Lime Down Solar Park – Applicant's response to advice and observations provided at Acceptance

Applicant's Response to advice provided under Section 51 of the Planning Act 2008

Applicant's Response to observations provided under Section 55 of the Planning Act 2008

APFP Regulation: 5(2)(a)
Application Doc no.: EN010168/APP.6.2
Drawing no.: 317212/11.3.1

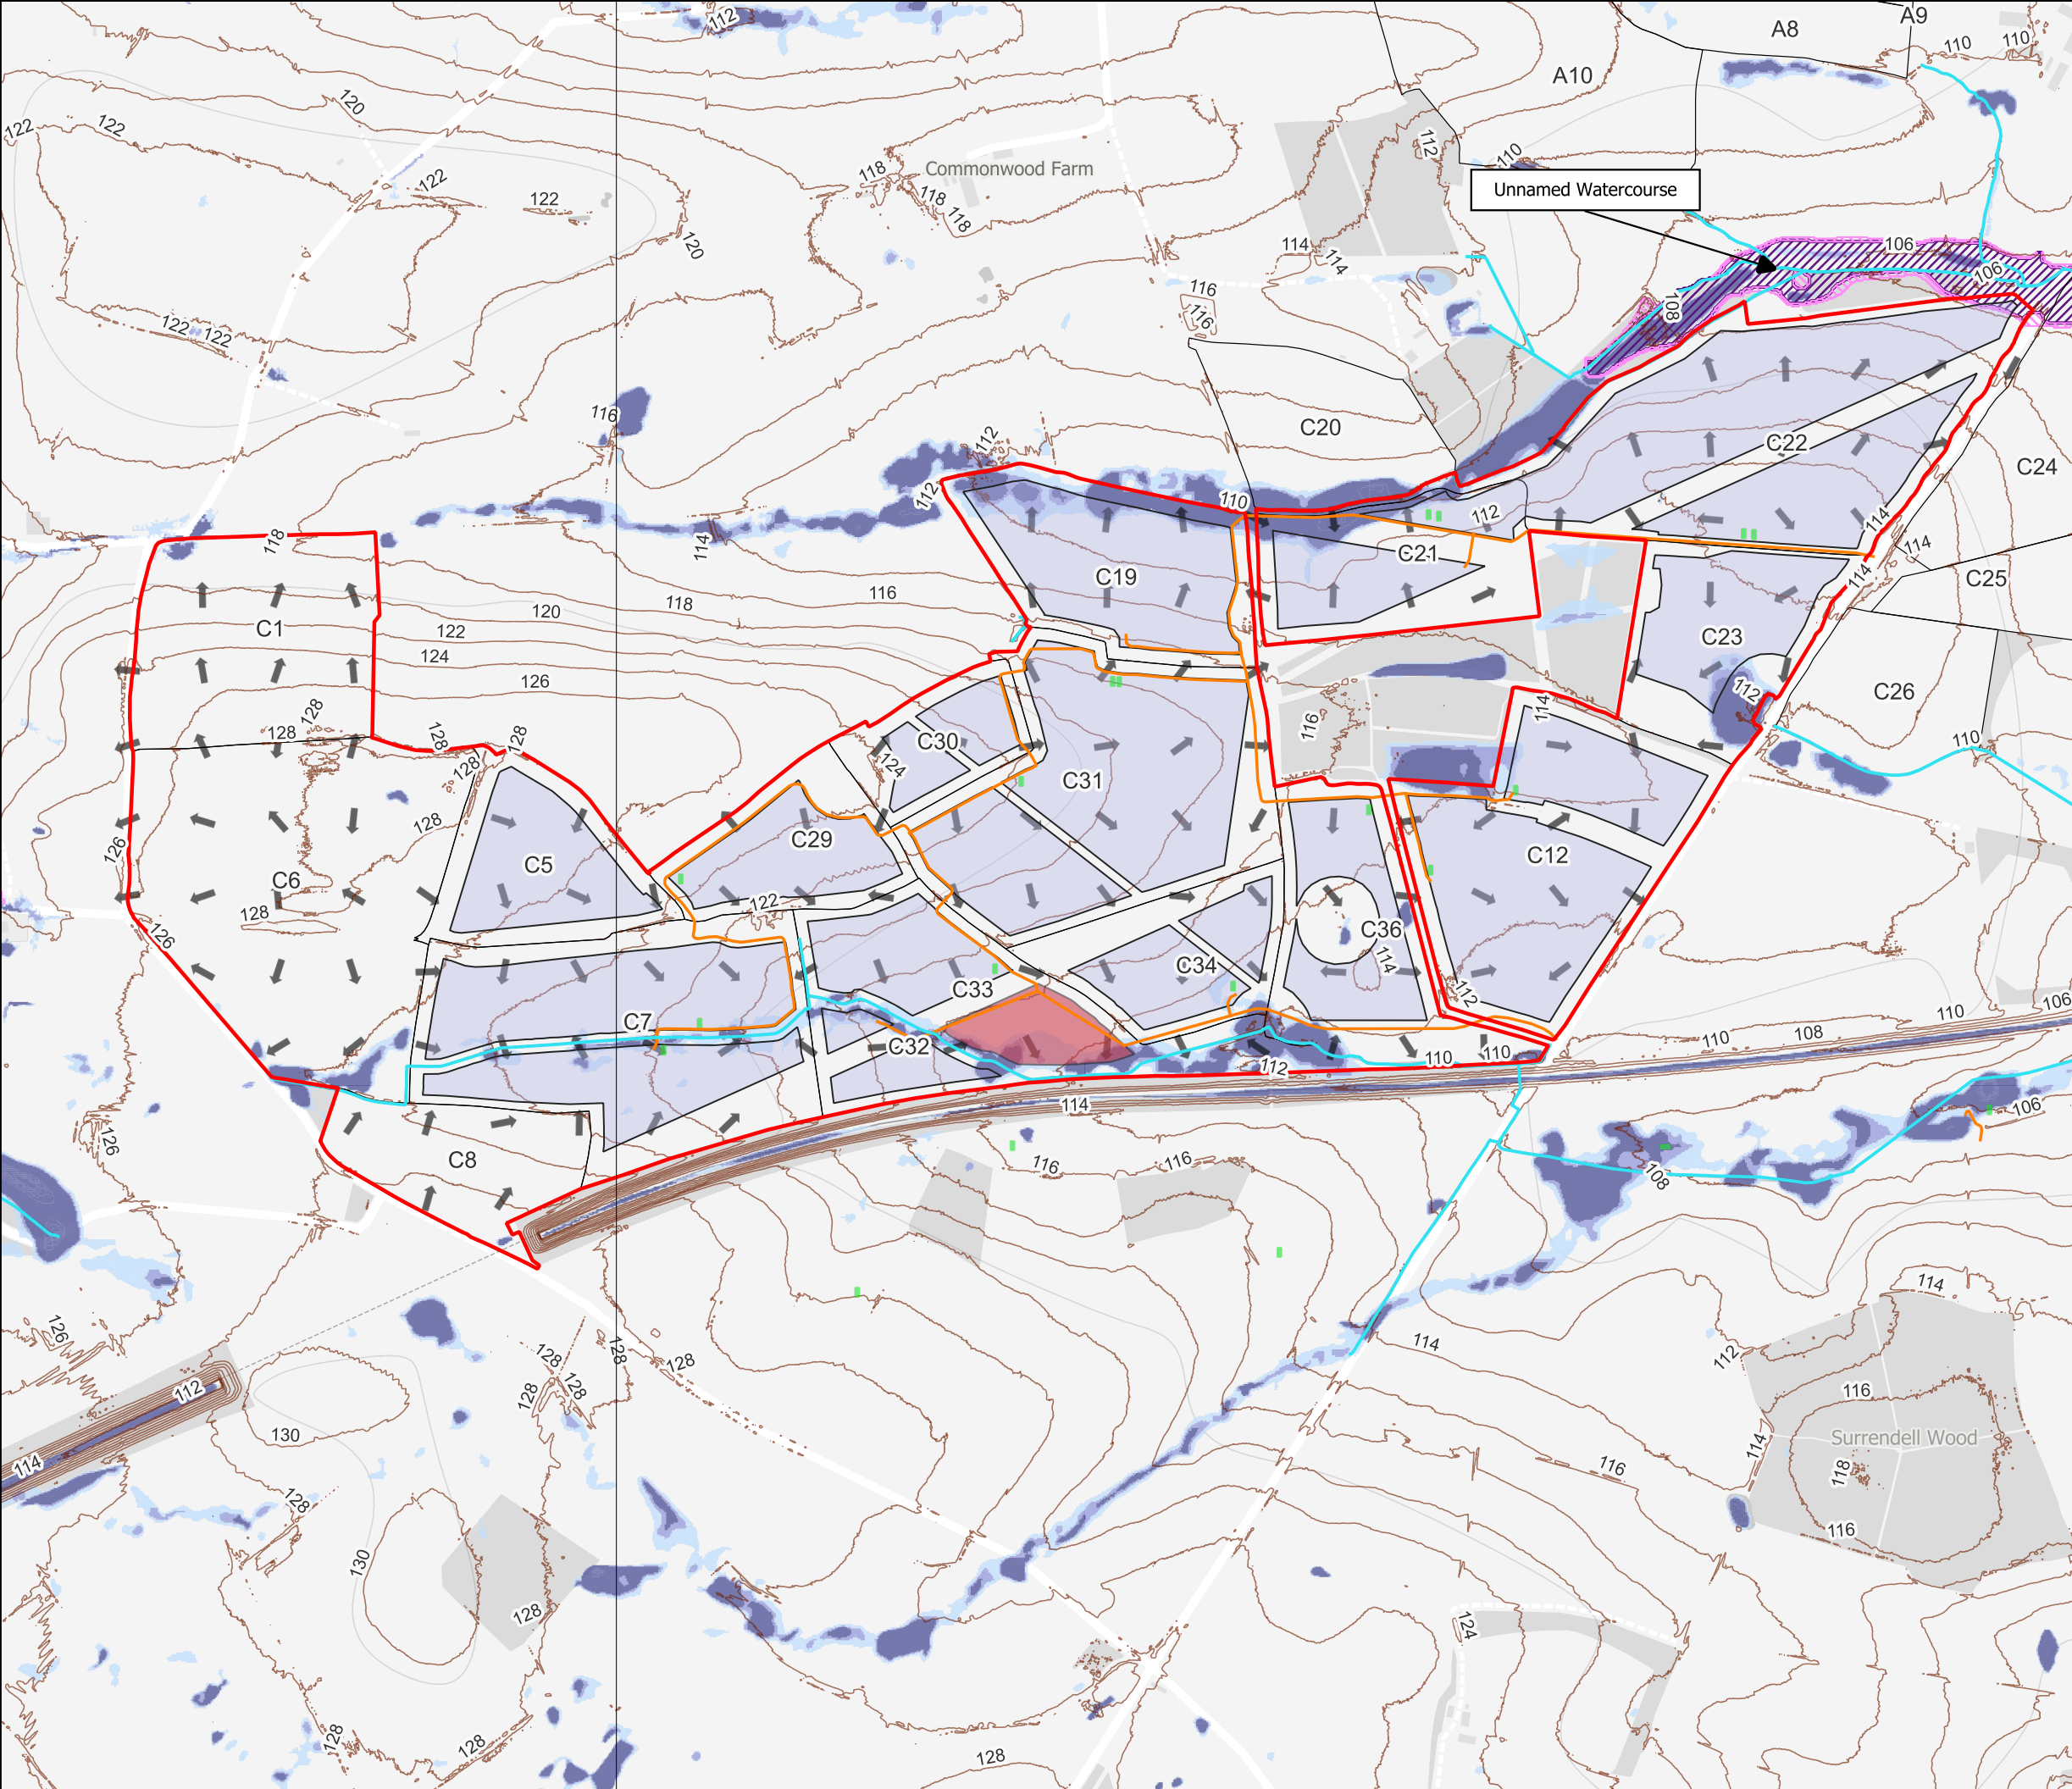
Advice under Section 51	Applicant's Response
	<p>perspective in line with standard assessment approaches. The embedded mitigation, particularly the site layout offsets, provides further confidence that no development is within functional floodplain. Given the approach has been agreed with the Environment Agency through consultation the Applicant does not propose to amend the Flood Risk Assessment and Drainage Strategy [APP-210 to APP-218].</p>
<p>Labelling of watercourses</p> <p>The FRA and Drainage Strategy (ES Appendix 11-1 to 11-9) provide sections setting out the site conditions and locations of waterbodies in the area. Figures have been provided displaying watercourses and bodies for each of the 'sites'. The names of watercourses and bodies have not been labelled on all these figures although where relevant, the location has been described in the text. The FRA should provide appropriate figures displaying labels for all named watercourses and bodies.</p>	<p>The Applicant will update the Flood Risk Assessment and Drainage Strategy set out at ES Volume 3, Appendix 11-1 to 11-9 [APP-210 to APP-218] to include labelling of the watercourses shown, and resubmit the documents at Deadline 1.</p>
